From: [REDACTED] >
Sent: 23 April 2026 14:07
To: Planning
Subject: Application 3/2025/0801 Salesbury view
Attachments: ab8eefa4-f977-4260-80bb-ee1c84dc01da-1_all_2268.jpg; ab8eefa4-f977-4260-80bb-ee1c84dc01da-1_all_550.jpg; ab8eefa4-f977-4260-80bb-ee1c84dc01da-1_all_1659.jpg; ab8eefa4-f977-4260-80bb-ee1c84dc01da-1_all_605.jpg; ab8eefa4-f977-4260-80bb-ee1c84dc01da-1_all_542.jpg; pro-p1Pj6jnl.jpeg; pro-cV4kRUDN.jpeg; pro-leawwSL3.jpeg

Having seen that the developer, Persimmon have made various changes lately to their application I was hoping that I may be able to comment further about the application.

Drawing Title
**DRAINAGE LAYOUT
SHEET 1**

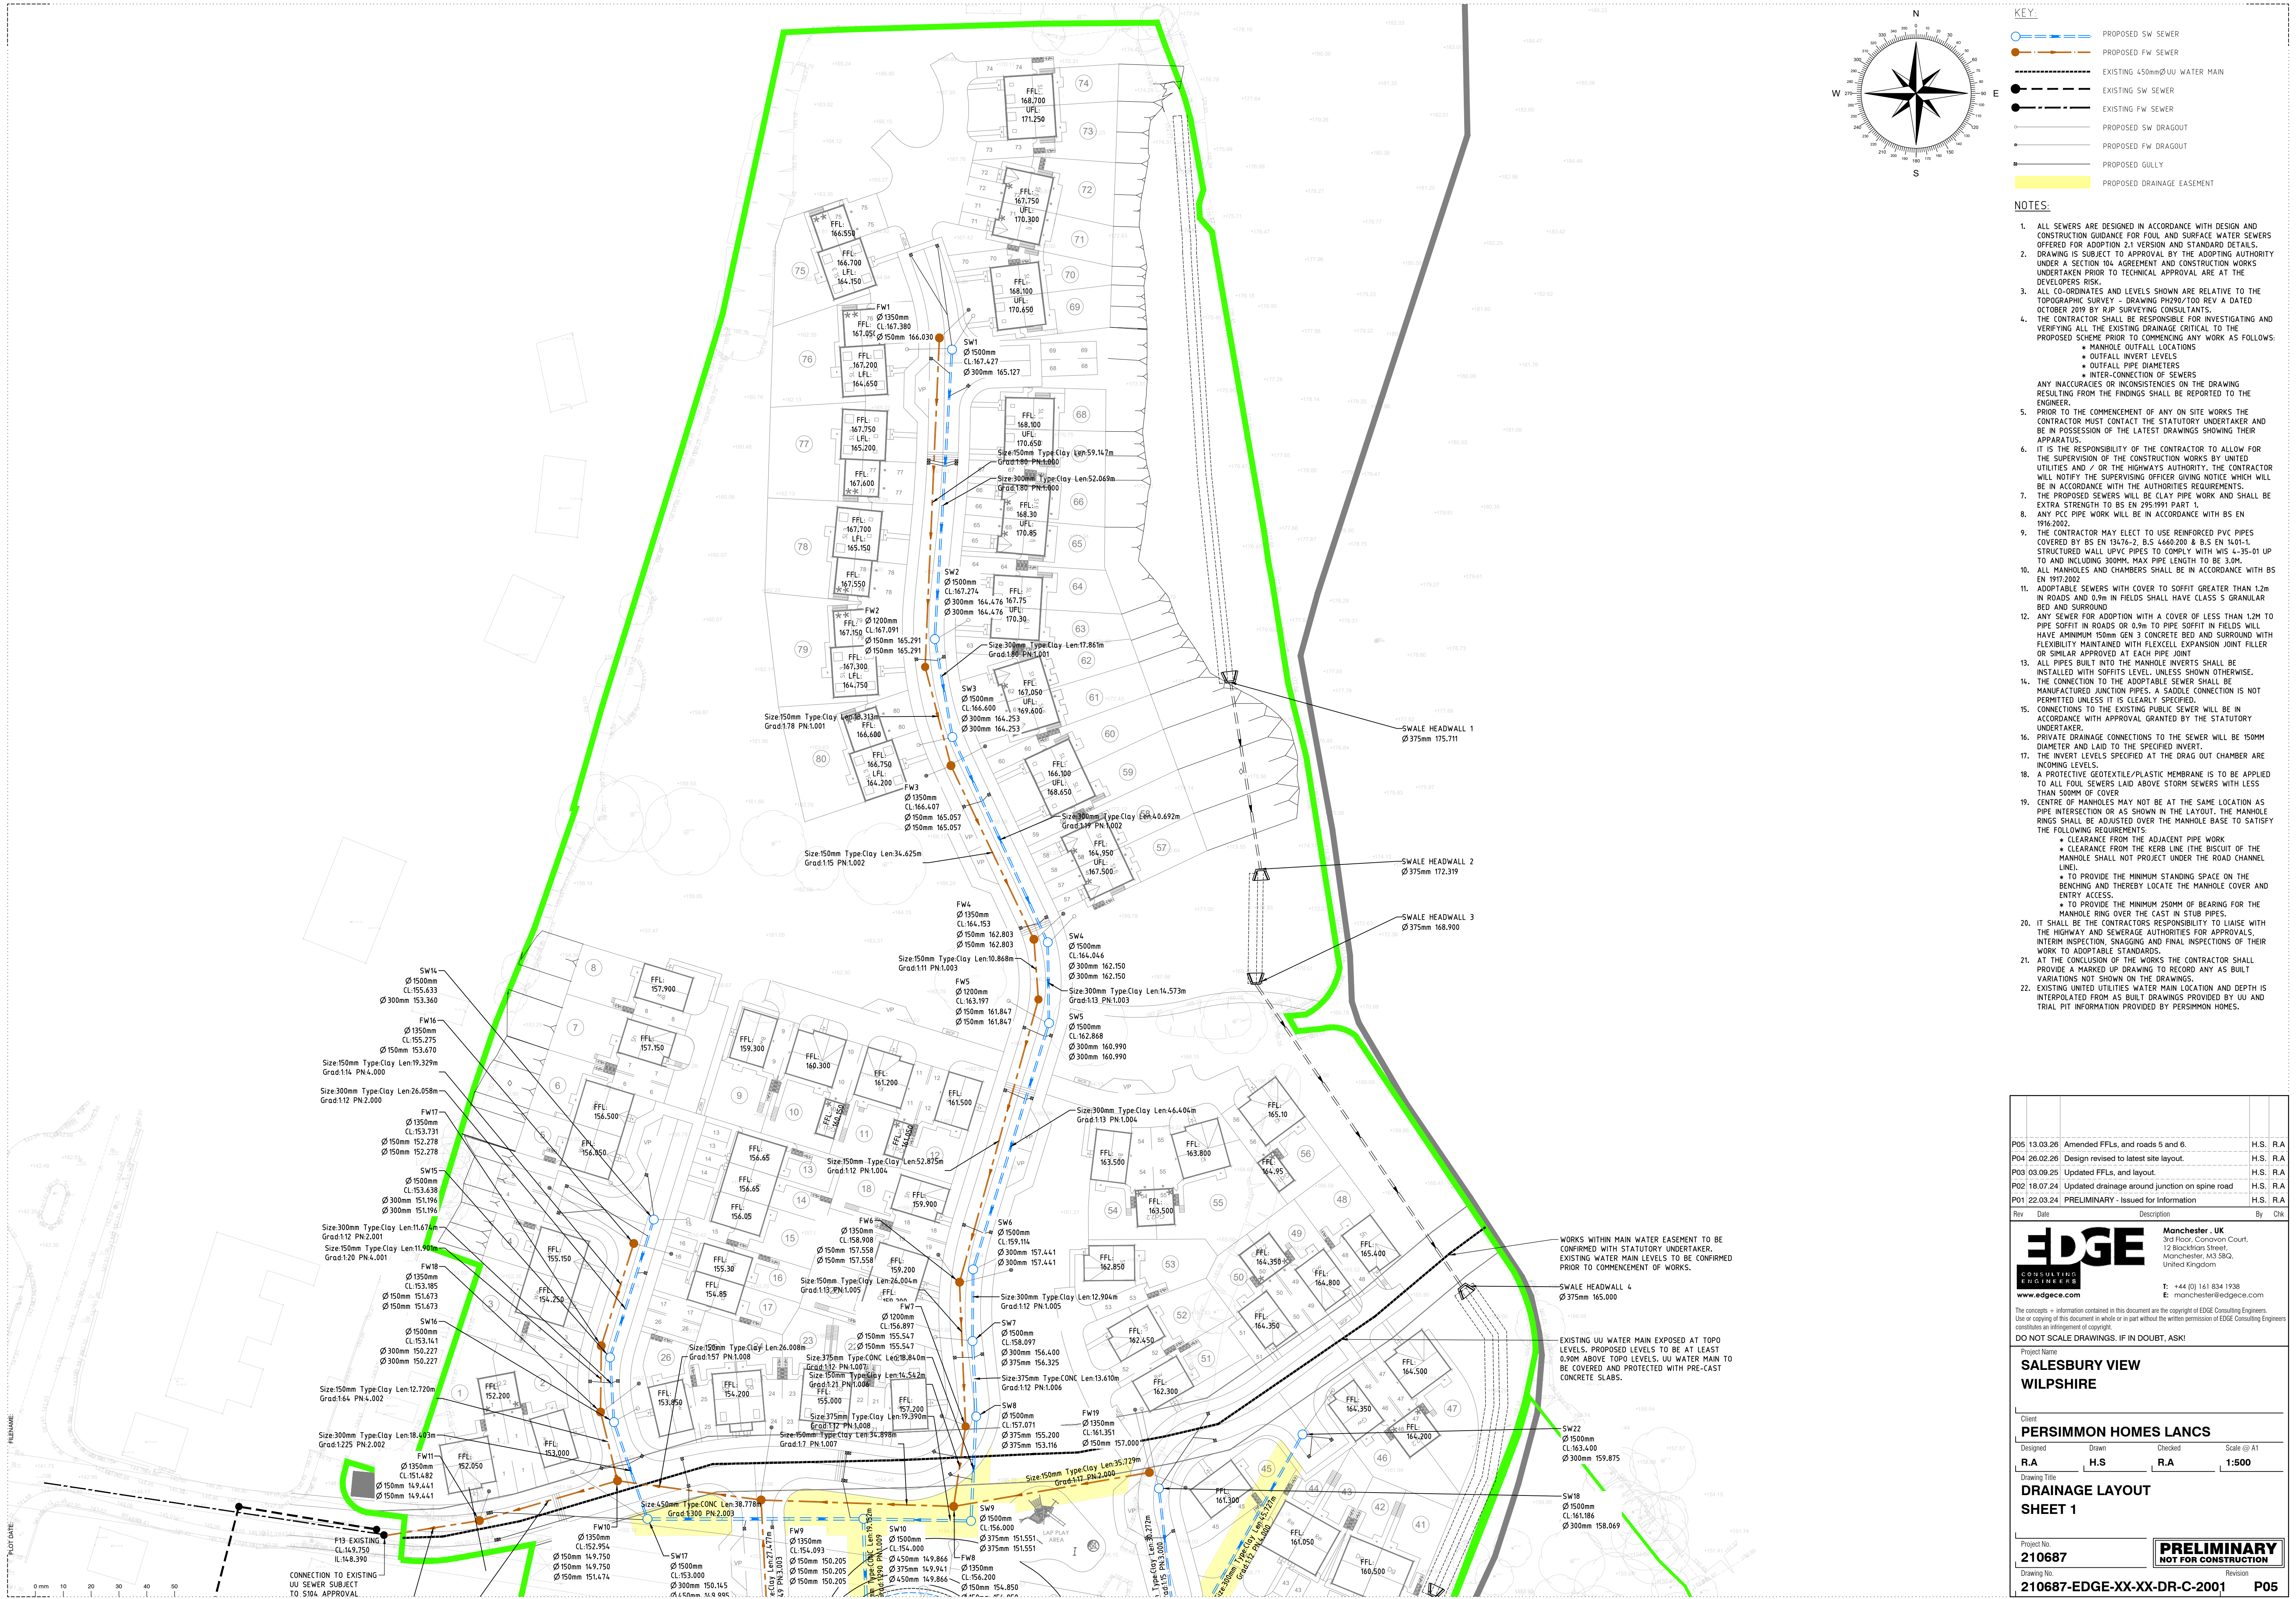
Persimmon claim to have found where the water mains run through the development east to west but as my photo shows the pipes run from North to South through the development I don't have to tell you cannot build over water mains so this development in its current state surely cannot be passed.
